Response to the CSELR Planning Modification Report (SSI-6042)

City of Sydney
Town Hall House
456 Kent Street
Sydney NSW 2000

December 2014

Figure 5.1d Key features of the CSELR proposal

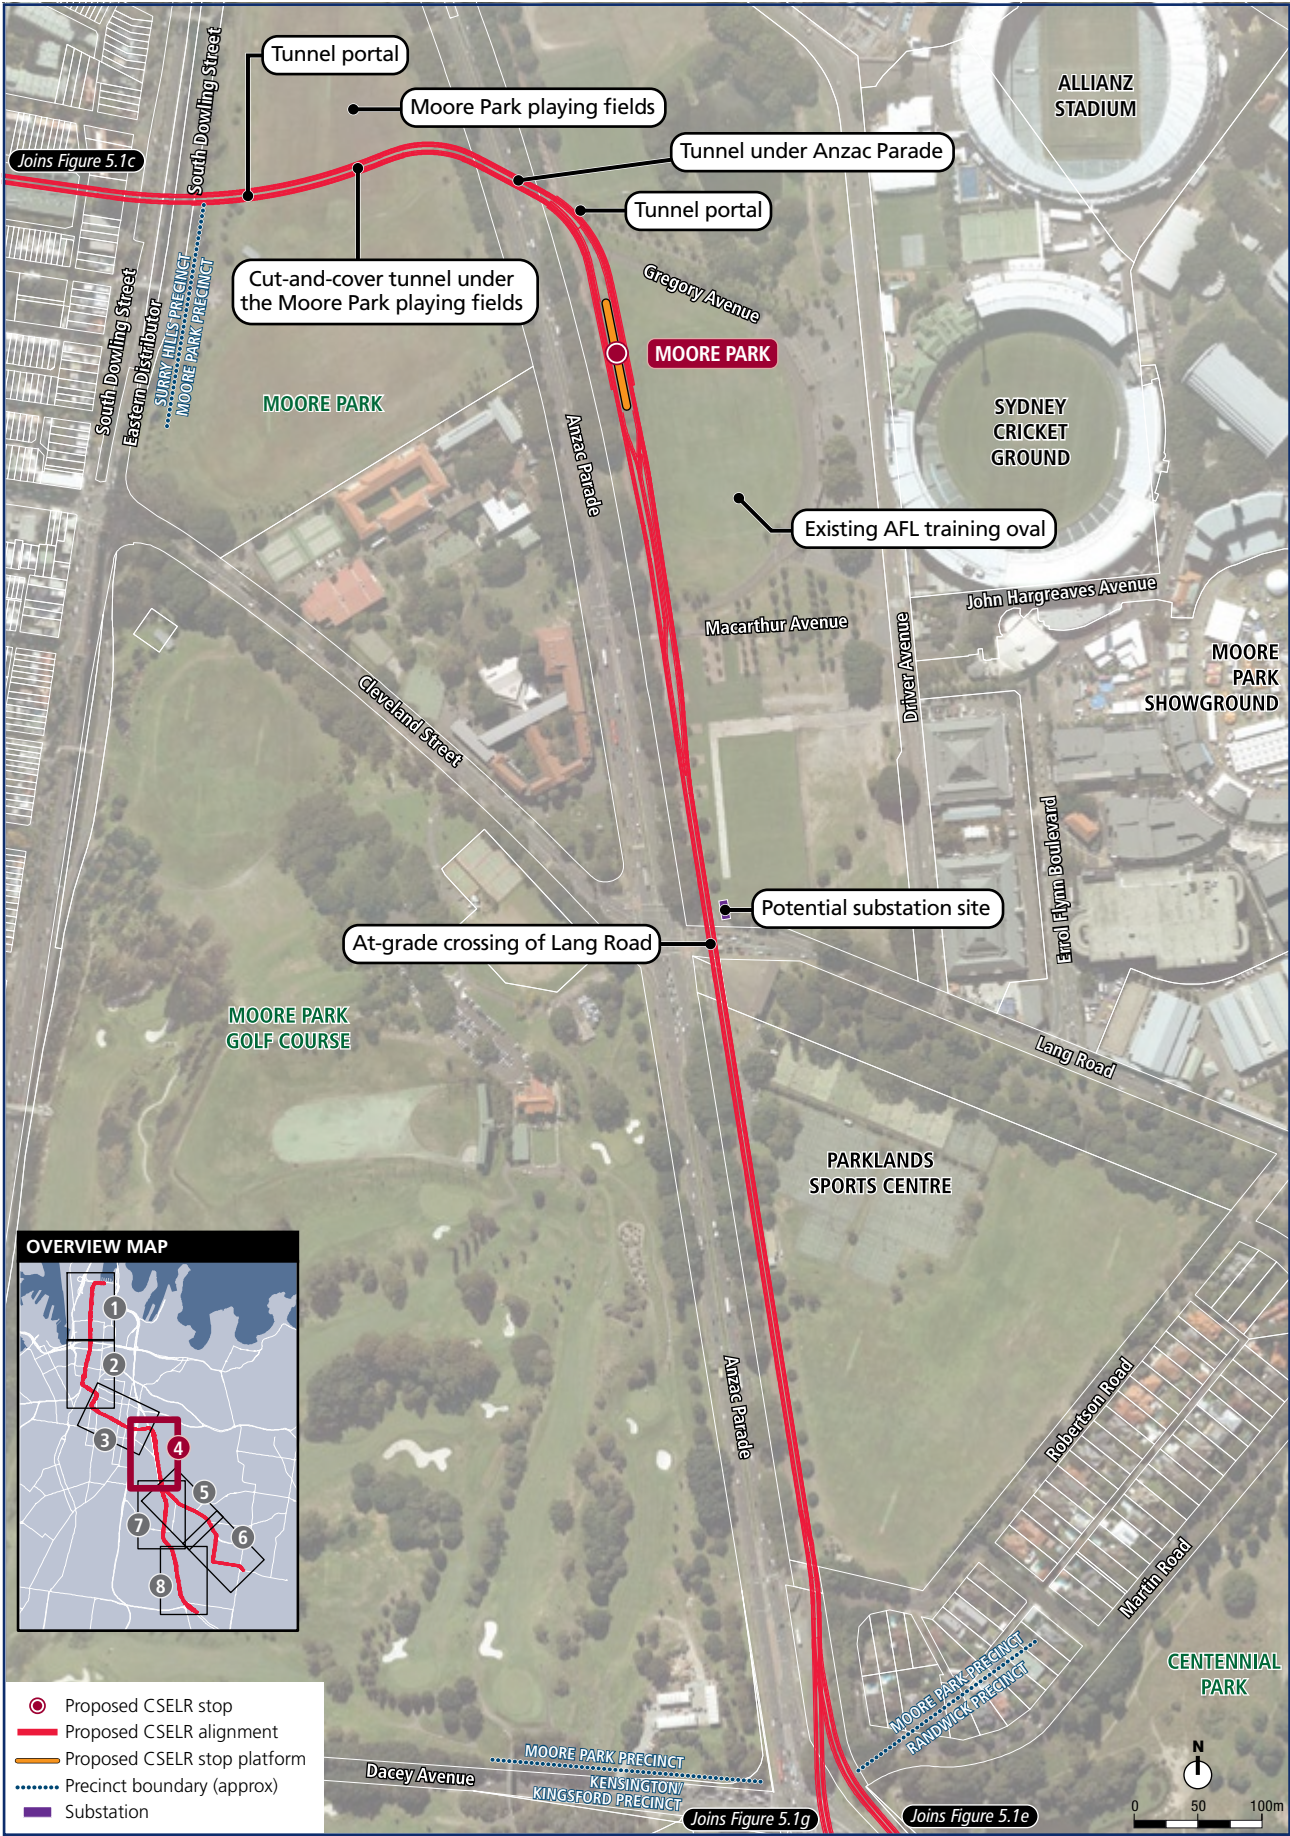
Revised substation sites	<p>The City supports the proposed relocation of the Surry Hills substation from the new Wimbo Park to be underground within the western portal of the Moore Park tunnel.</p> <p>However no clarification has been given about the final location of the Moore Park East substation. The project's Environmental Impact Statement identified the location of a substation on Moore Park East on the north eastern corner of Lang Road and Anzac</p>

Parade as per extracted figure 5.1b below:

Table 4.2 of the Submissions Report, Volume 1 on page 4-9 stated: “Preference for below ground substation at Moore Park or integration with new amenities building near tennis centre”, with Figure 6.2d (image below) of the same volume of the Submissions Report, on page 6-6 showing the proposed substation on the southern side of the intersection of Lang Road and Anzac Parade. This is contradictory as the image shows one location and yet the table gives two options.

Figure 5.8 Indicative plan – Grosvenor Street stop

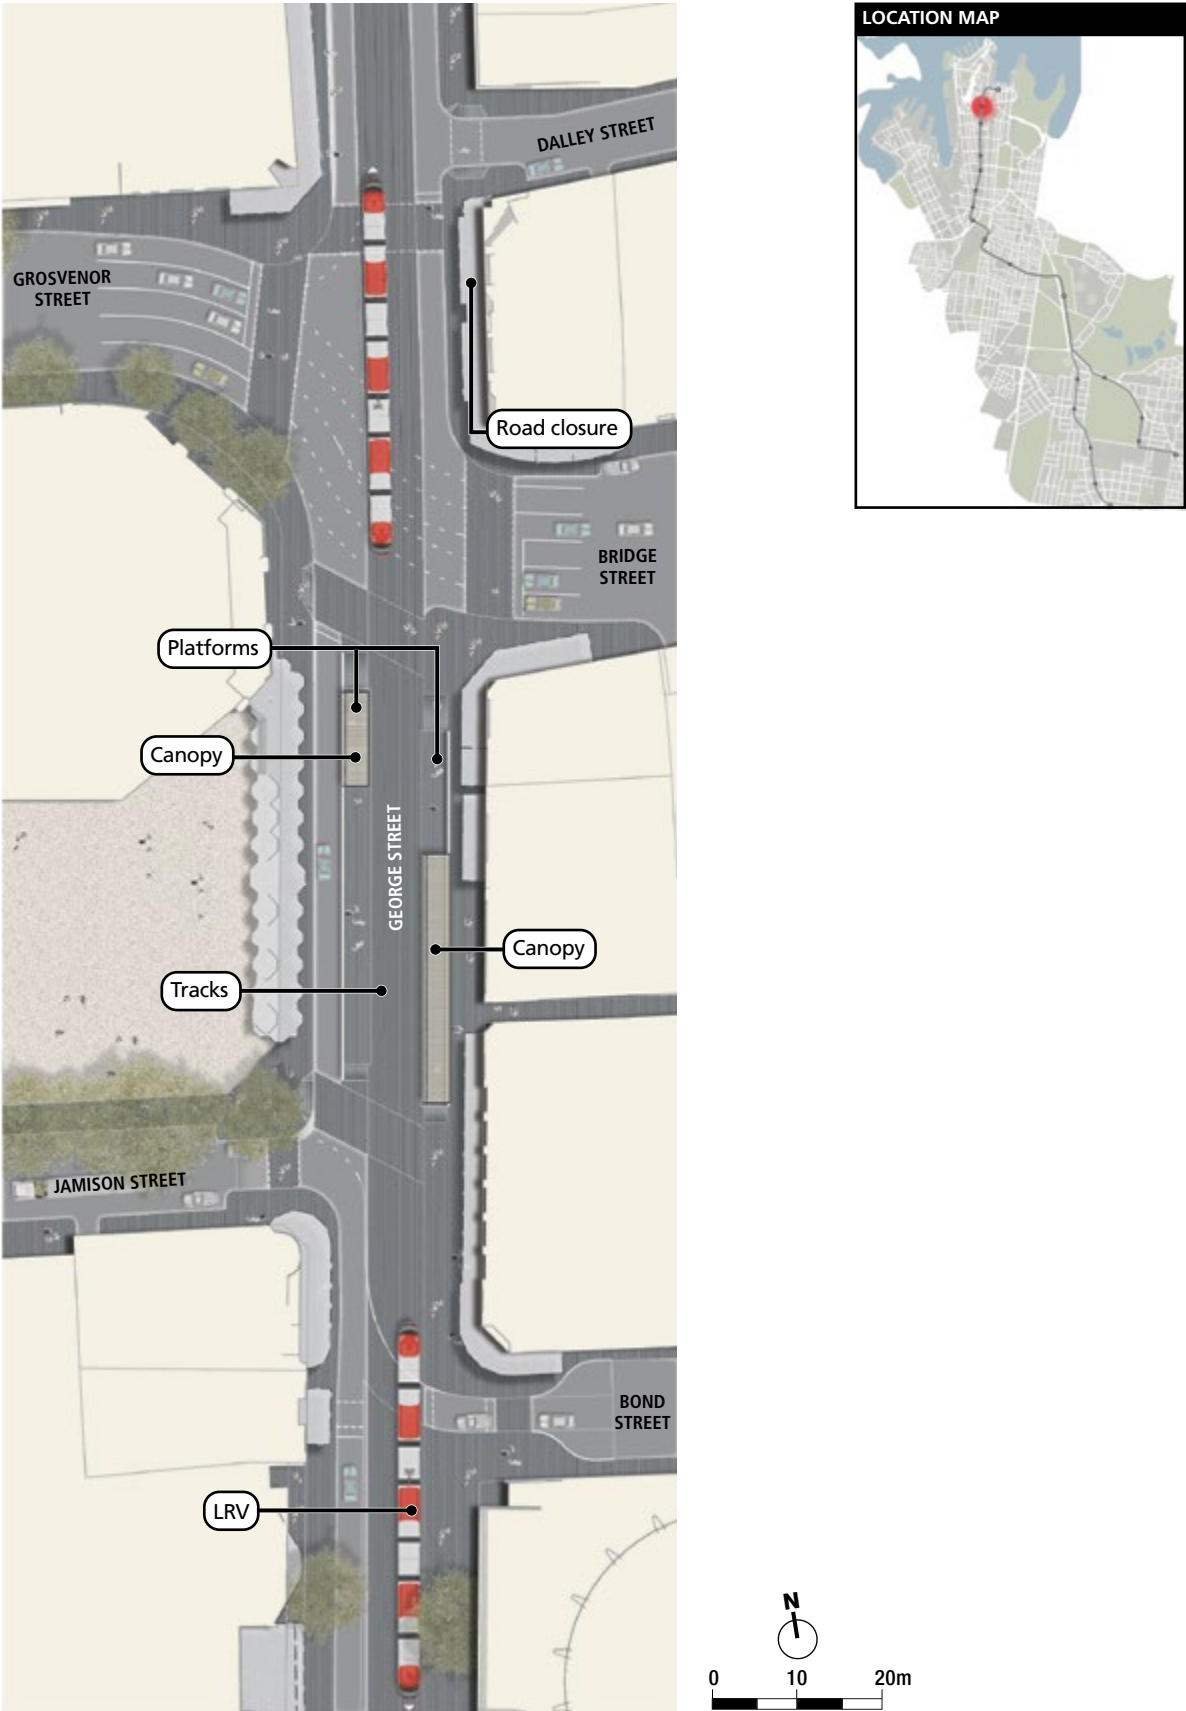
The new arrangement does not provide the following:

- Reduced functionality of the stop, as there will be no direct passenger access to the platform from the eastern footpath, which will be subject to the highest passenger load (in the PM peak);
- No additional footpath width for eastern and western footpaths;

The City's preference is to maintain a side platform arrangement wherever possible for overall network consistency and wayfinding legibility and to reinforce the view corridor that already exists along George Street. The City is also concerned that the island platform does not allow for future proofing of a larger pedestrian environment.

In addition, footpath widths must not be reduced below the widths specified in Clause 1.6.9 of Schedule 7 - Technical Requirements of the Development Agreement that TfNSW has entered into with the City of Sydney.

Delete proposed left hand turn from George St to Grosvenor St;

Revert to previously approved side platform arrangement;

Widen eastern and western footpaths on George St as previously approved;

Comply with minimum paving widths as per Clause 1.6.9 of Schedule 7 - Technical Requirements of the Development Agreement.

Figure 5.16 Indicative plan – World Square stop

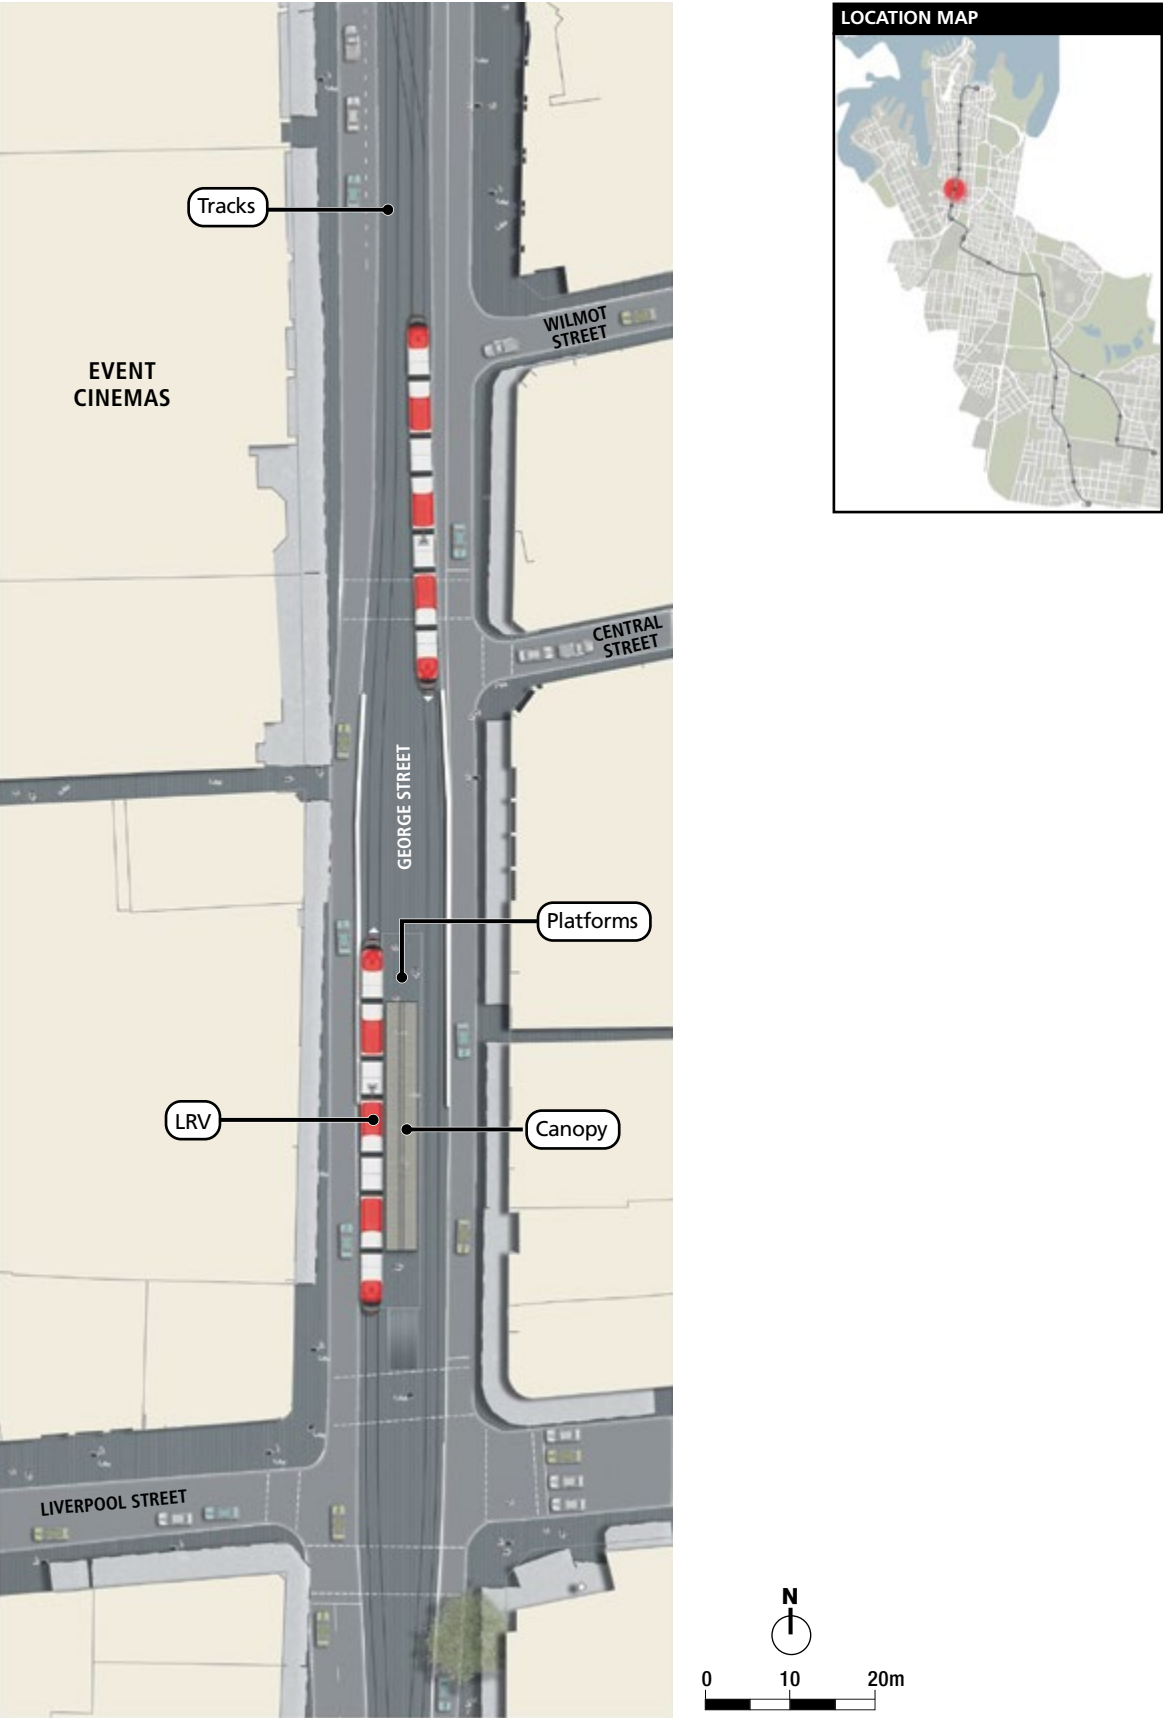
The City supports removal of the World Square platform provided footpaths on the eastern and western sides of George Street from Liverpool Street to Bathurst Street are widened.

The change also eliminates the need to trim the south west corner of the George Street and Liverpool Street intersection to provide a dual lane left turn (north to west) for the Liverpool Street cycleway.

Below shows the possible footpath improvements (in red) that the City is seeking to be included as conditions following the elimination of the World Square stop, in addition to the proposed widening along both sides of George St between Wilmot and Bathurst Sts.

Widen pavements as shown in above sketches, in addition to the proposed widening along both sides of George St between Wilmot and Bathurst Sts.
